From: Richard Tyler [REDACTED]
Sent: 03 July 2026 18:44
To: Botley West Solar Farm
Subject: Submission re EN010147

As a local resident and interested party I would like to raise the following points for consideration by the SoS in assessing the merits of granting or withholding planning permission on the proposed Botley West Solar Farm development.

Title: Illustrative Masterplan
Figure 5.3: Cable Corridor Plan Overview - Area between the Northern and Central Sites on land to the east of Woodstock and in the vicinity of the Bladon roundabout on the A44

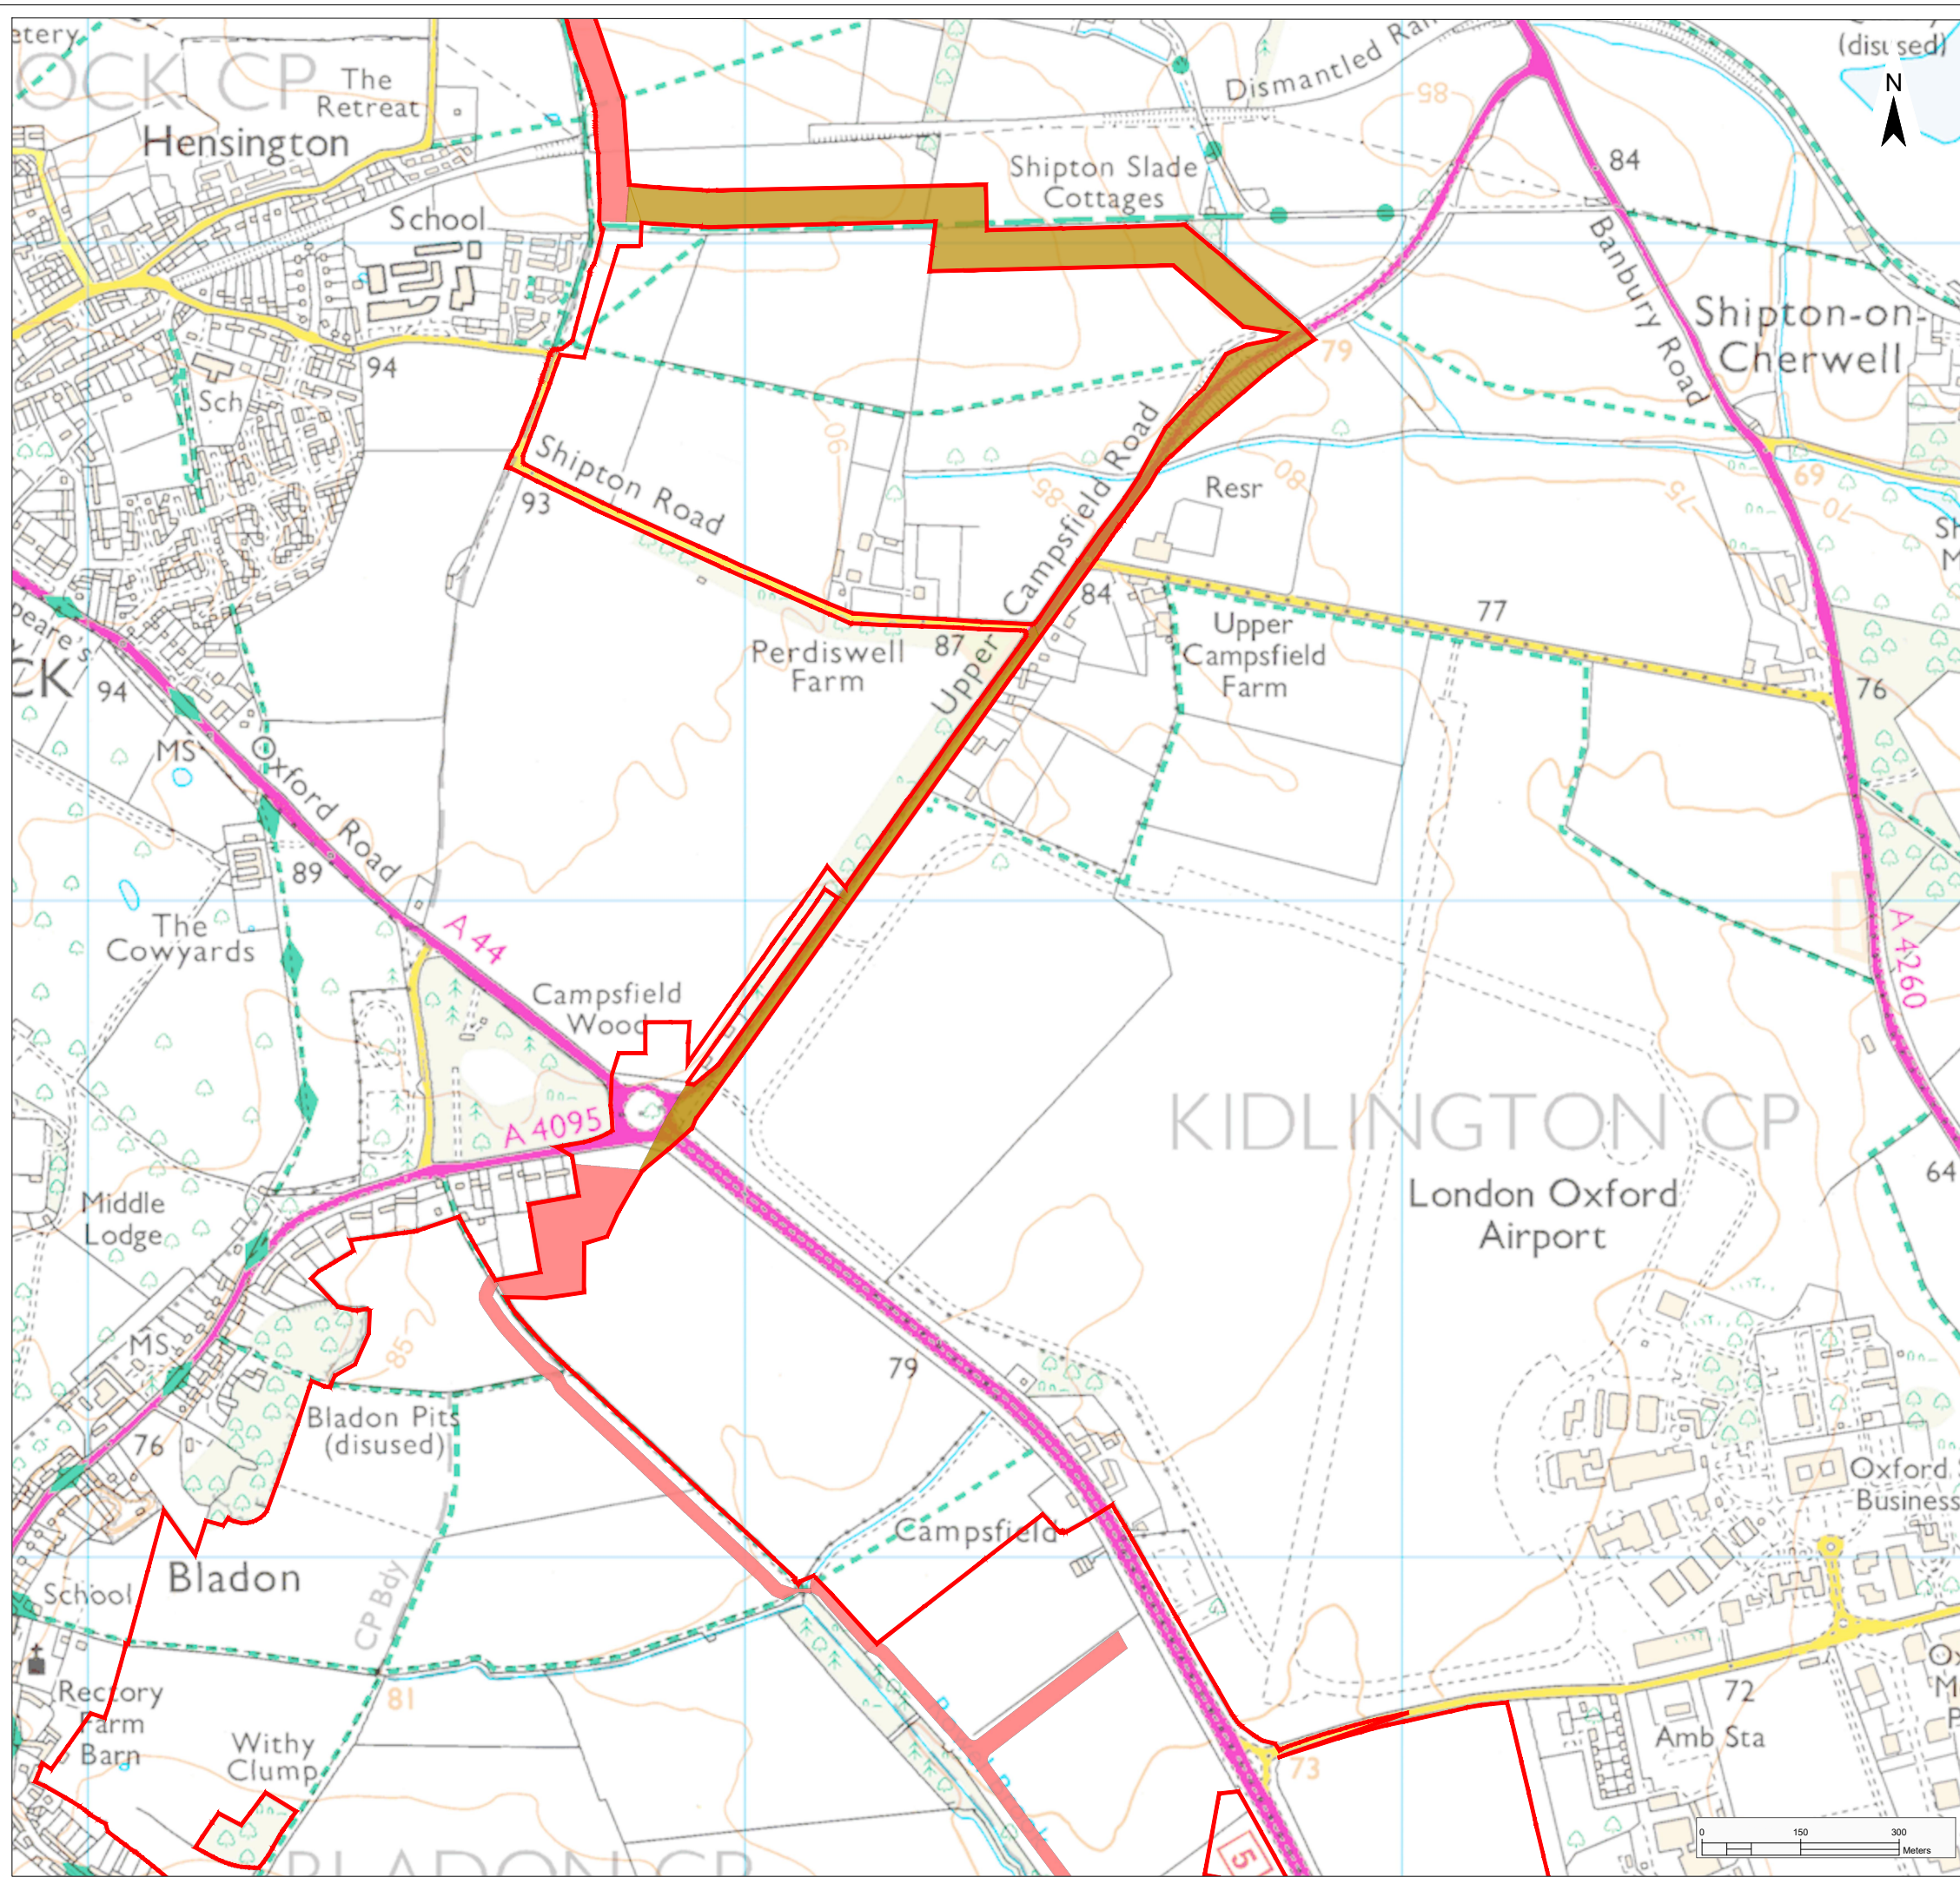
2) Document C1-050 - illustrative master plan: This map does not include the recent development of c300 homes on the edge of Woodstock at Park View, nor the land owner's plans for a further 500 homes on the adjacent site, around which the proposed PVDP cable is to be laid.

House building is important in Oxfordshire and should continue. But omitting it highlights that this solar power infrastructure planning application is being taken in isolation from other significant construction projects that residents in Woodstock and Bladon are also living with, which impact road congestion, amenities and the views of place.
